Our Ref: LM/ARU/20/25A

Date 2nd September 2020

RE: Land to the south of Ford Lane and East of North End Road Yapton BN18 0DS

Thank you for your correspondence of the 26th August 2020, advising me of a planning application for Approval of reserved matters following outline consent Y/80/16/OUT for 4.5ha of residential development comprising of 3.4ha of land for the erection of 100 No. dwellings (up to 30 (30%) affordable housing) together with 1.1ha of land set aside for public open space, strategic landscaping, 2.2ha of public open space, green corridors with vehicular access from Ford Lane & pedestrian/cycle access only from North End Road (resubmission following Y/19/20/RES). This application may affect the setting of listed buildings, affects the character & appearance of the Church Lane, Yapton Conservation Area & affects a Public Right of Way. This site falls within Strategic Site SP2 (Zero Rated) at the above location, for which you seek advice from a crime prevention viewpoint.

Detailed Play Provision - LEAP

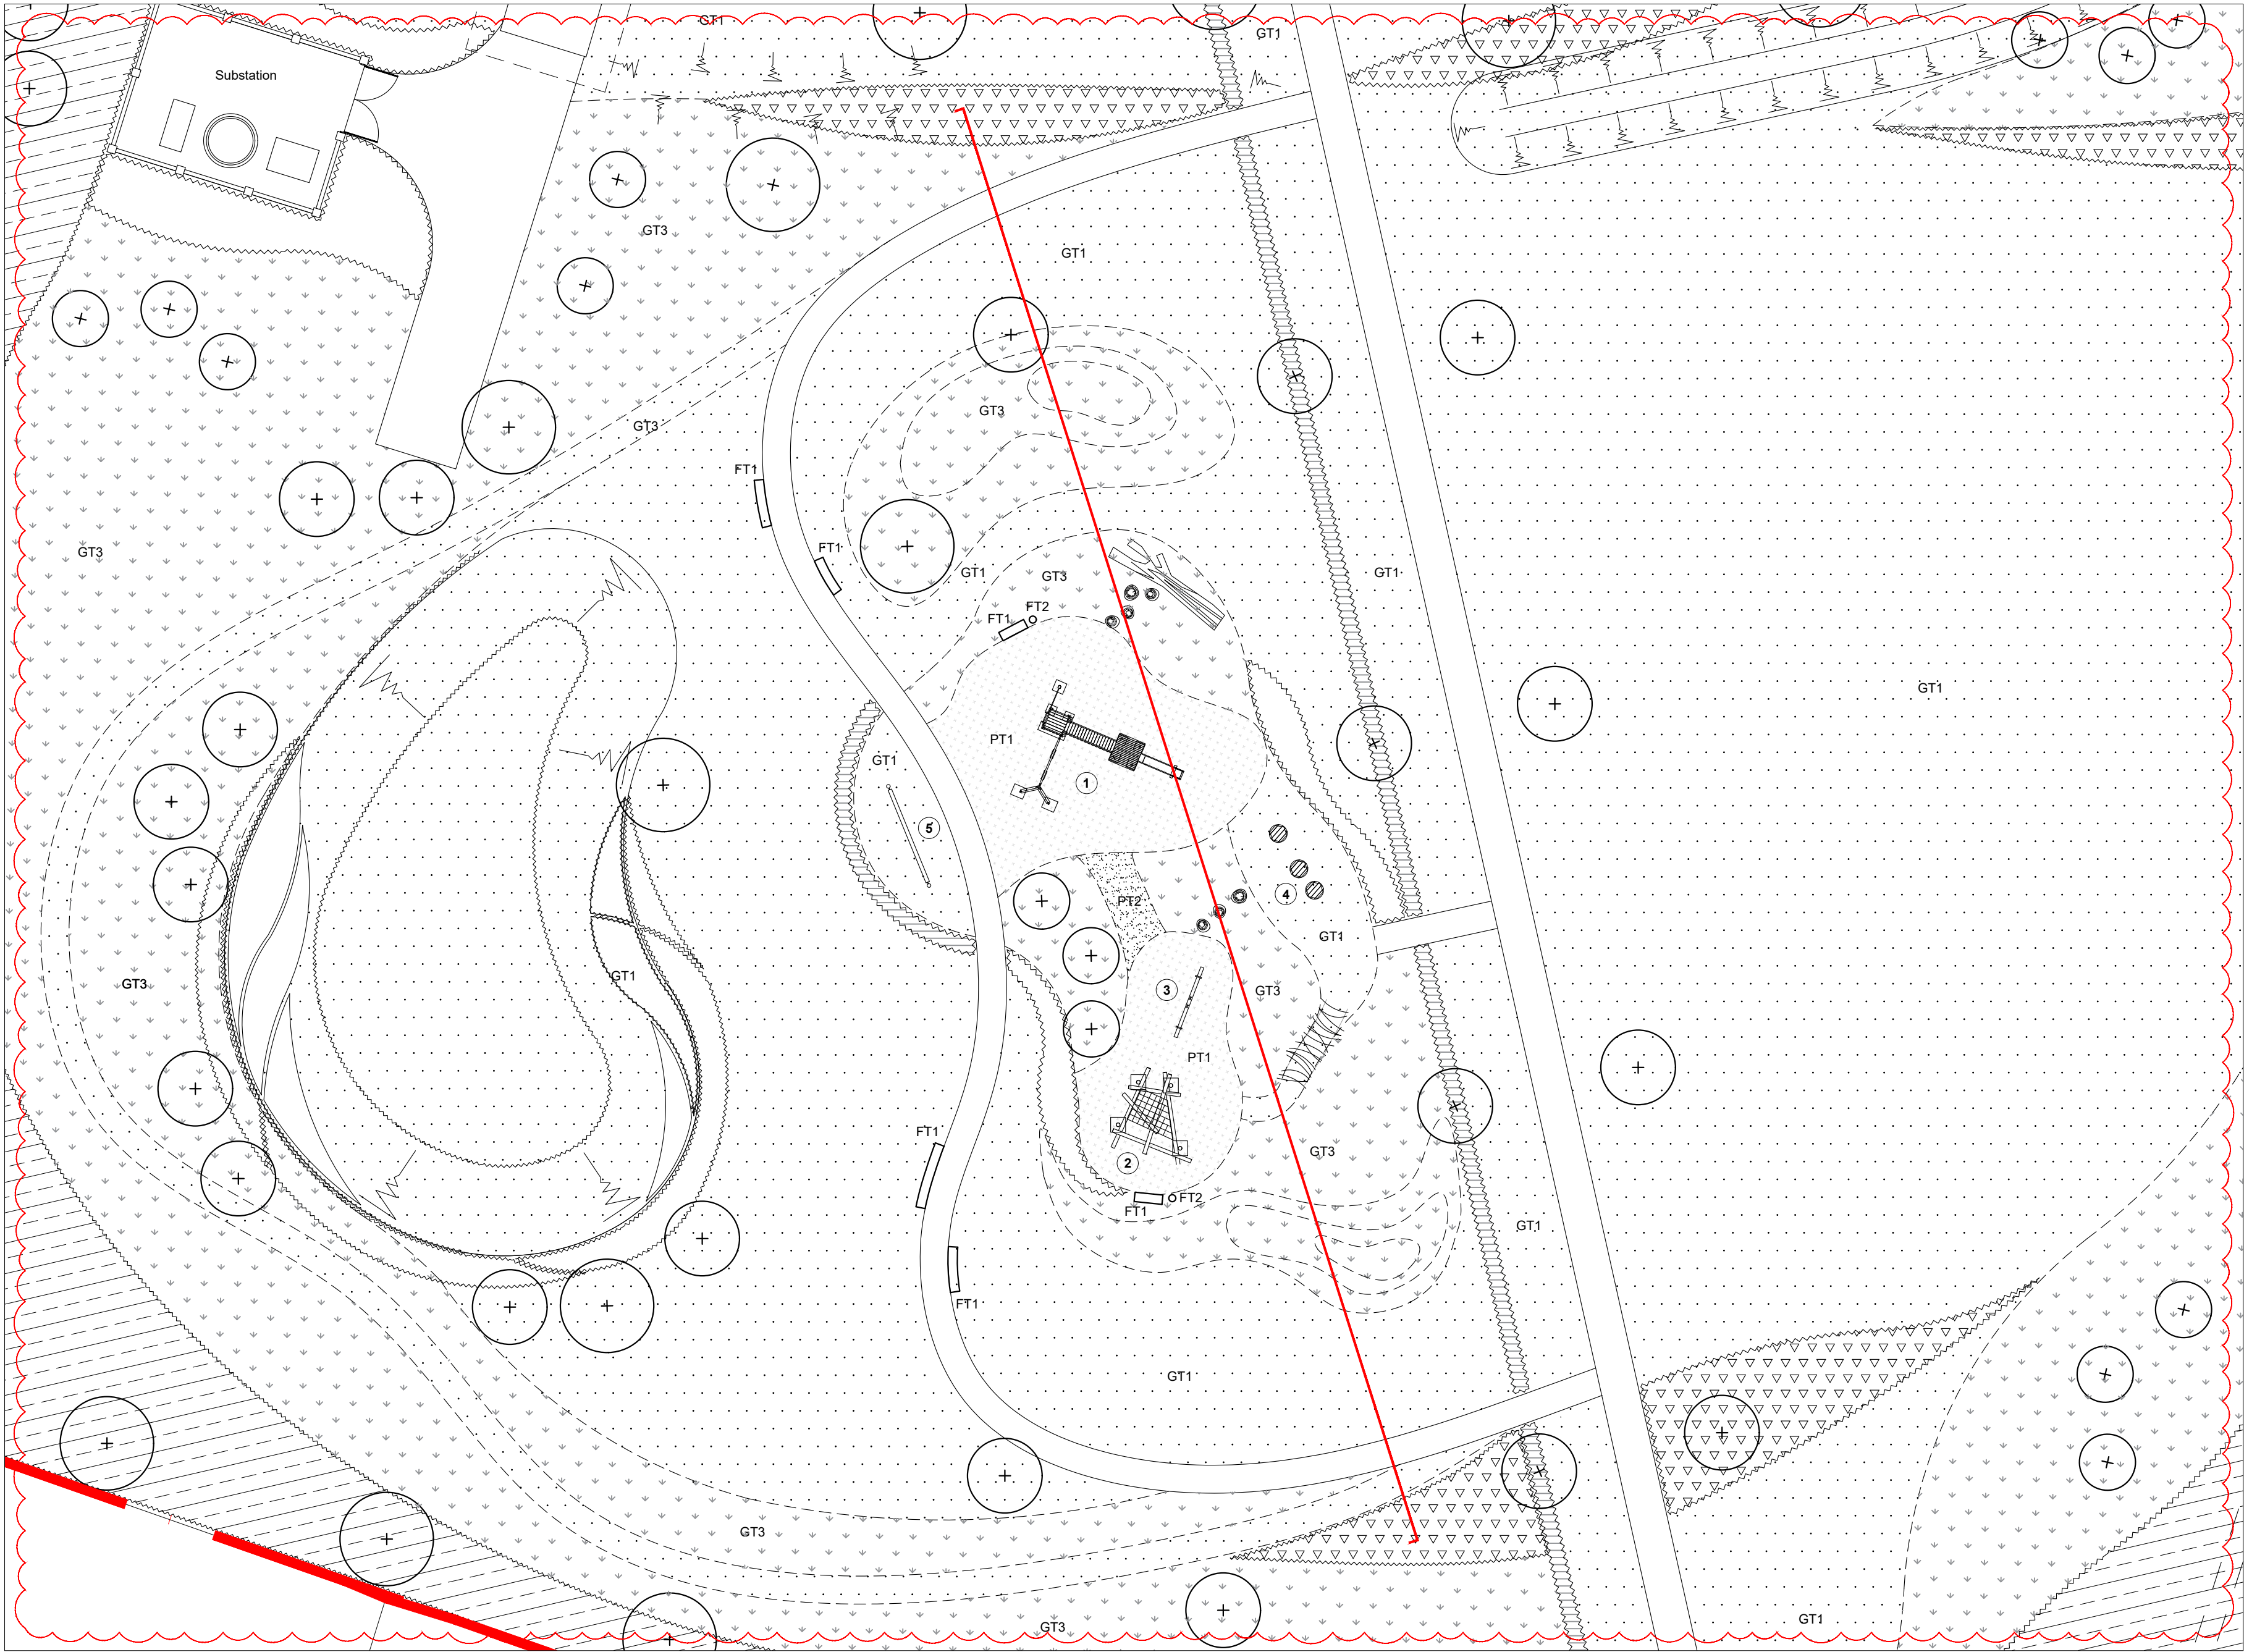
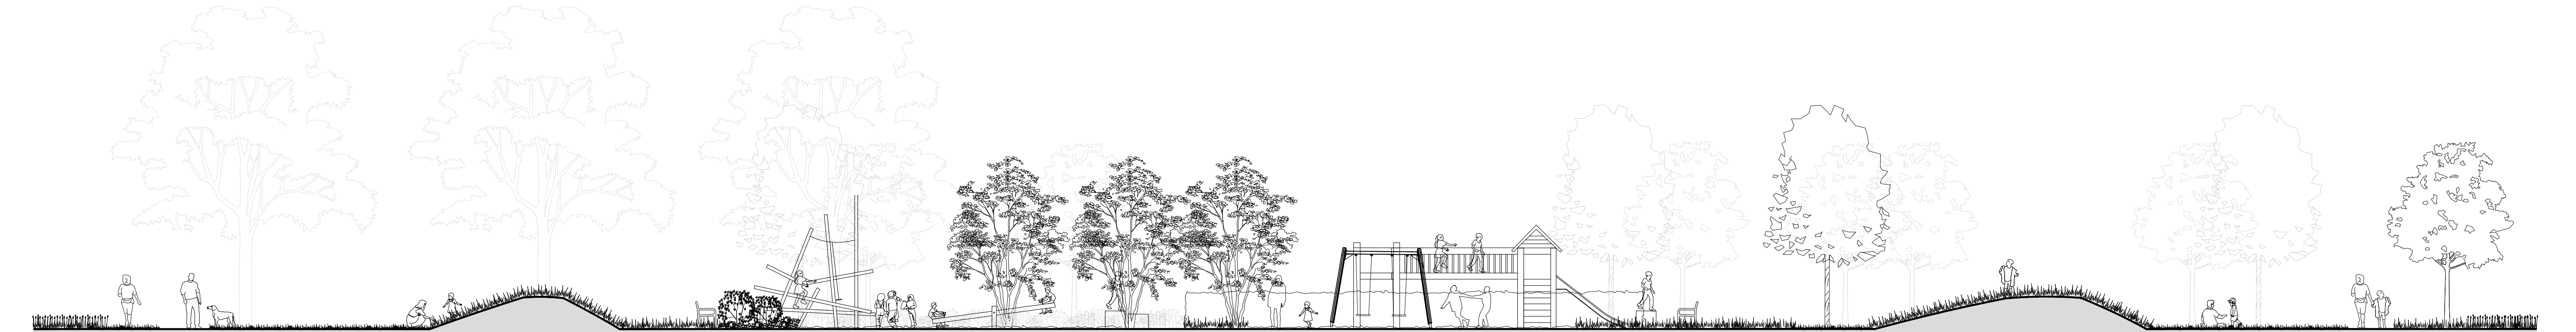
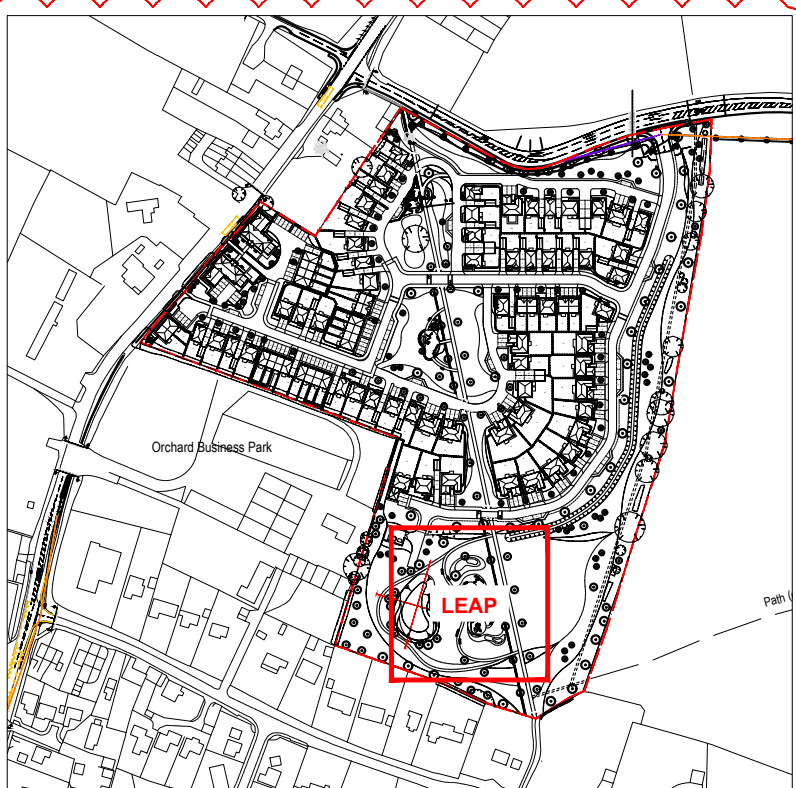
With regards to the LAP - areas of play should be situated in an environment that is stimulating and safe for all children, be overlooked with good natural surveillance to ensure the safety of users and the protection of equipment, which can be vulnerable to misuse. They should be designed to allow natural surveillance from nearby dwellings with safe and accessible routes for users to come and go. Boundaries between public and private space should be clearly defined and open spaces must have features which prevent unauthorised vehicular access. I would ask that when consideration is given to the eventual location that it is surrounded with railings with self-closing gates to provide a dog free environment.
